The Planning Inspectorate

Our Ref: TR030002

Date: 6 November 2014

Further to our meeting on 4 November 2014, please find attached to this letter the Planning Inspectorate's comments on the core draft documents for the York Potash Harbour Facilities Order project.

DRAWING No.	REVISION
PB1586-SK92	8

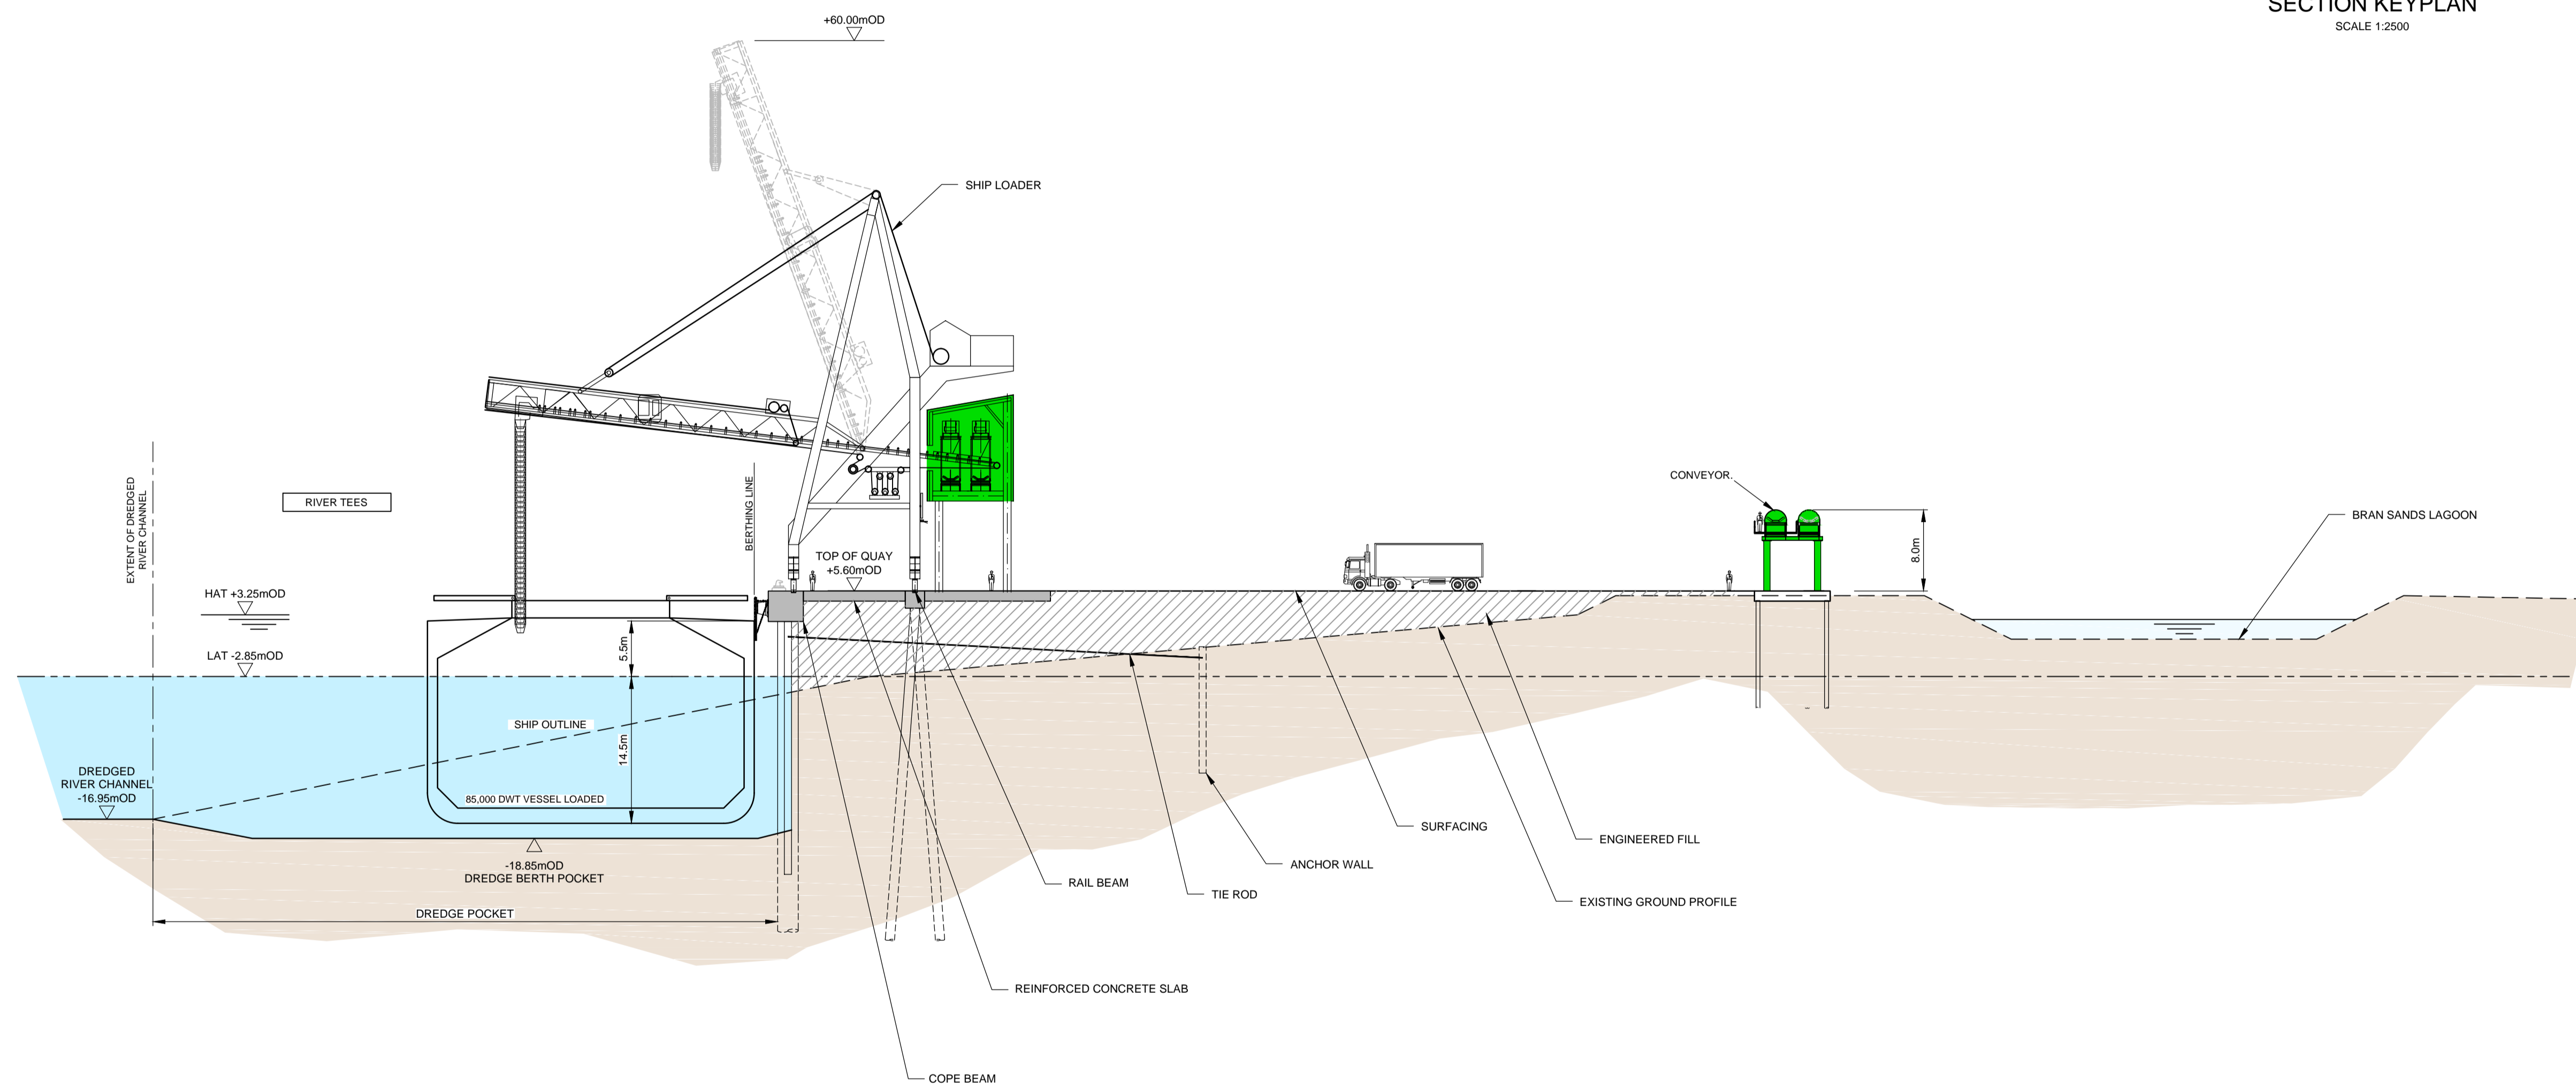
The works describe the quay being constructed in two phases being either a quay of solid construction or a quay of open construction. The applicant should explain in the EM why it is not possible to determine which option would be appropriate at the time of submission of the application and when it is envisaged that this decision will be made. The applicant should also ensure that the effects of both have been fully assessed within the ES.

The applicant should also explain the 2 stage approach and how this is secured within the DCO. At present there does not seem to be any description or indication of what the two phases consist of and thus it is not clear exactly what development consent is being sought for or when the demolition of the proposed jetty will be authorised in accordance with 1(2).
